**Re: Objection against SSD-77211717 – Lot 303 Croatia Avenue, Edmondson Park**

Bathla Group is the registered proprietor and consent holder for the mixed-use apartment precinct currently the subject of an active and approved Development Application for 164–170 Croatia Avenue, Edmondson Park (Lots 25 & 26 DP 228850).

DS-12 Interface Section - Driveway
Scale 1:100

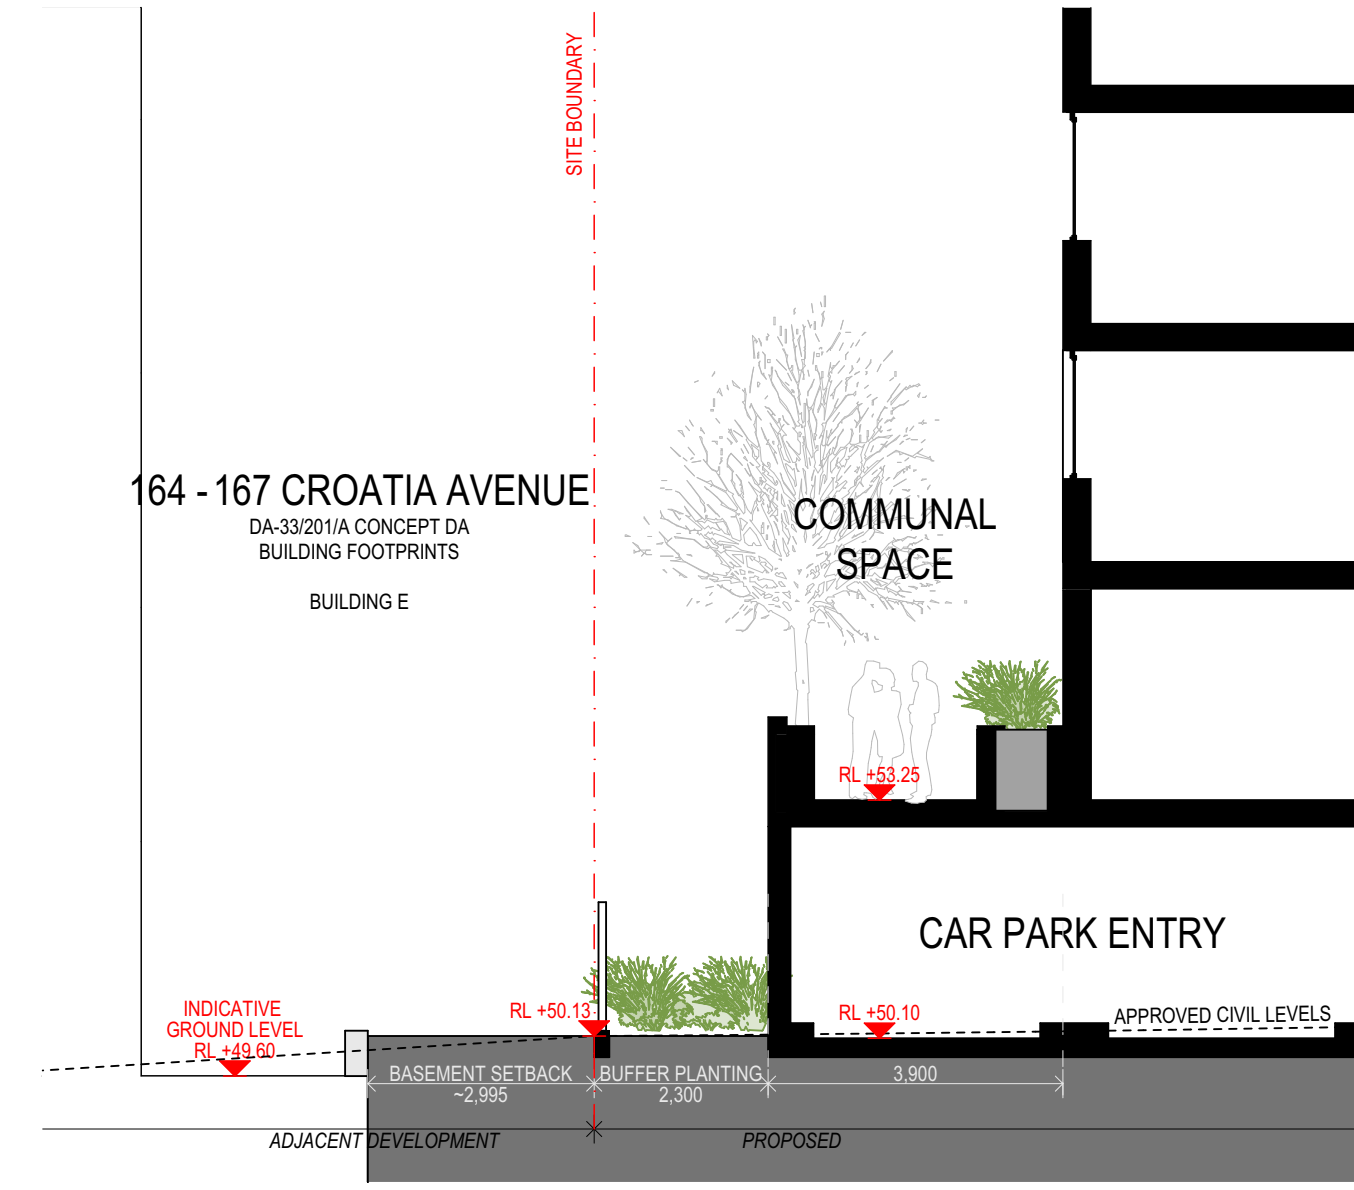
- (1) Communal Open Space: Afternoon overshadowing of our landscaped courtyards contravenes ADG 3D-1, diminishing winter usability.
- (2) Visual Privacy: Direct inter-apartment sightlines at distances < 12 m breach ADG 3F-1, eroding resident privacy.
- (3) Streetscape: The continuous podium and minimal articulation along Soldiers Parade fails LDGP 10.5 objectives for a “human-scaled, fine-grained street edge”.

- (1) Refuse the SSD in its current form or Require substantial design amendments, specifically:
  - (i) Reduce Block 24 height by at least two storeys;
  - (ii) Introduce a minimum 6m setback from any part of the building and 9m upper-level setback from the common boundary;
  - (iii) Articulate façades and break building mass into smaller elements;
  - (iv) Provide verified shadow diagrams demonstrating that ≥ 70 % of dwellings on adjoining sites still receive the minimum 2 hours solar access at mid-winter, with ≤ 15 % receiving none.
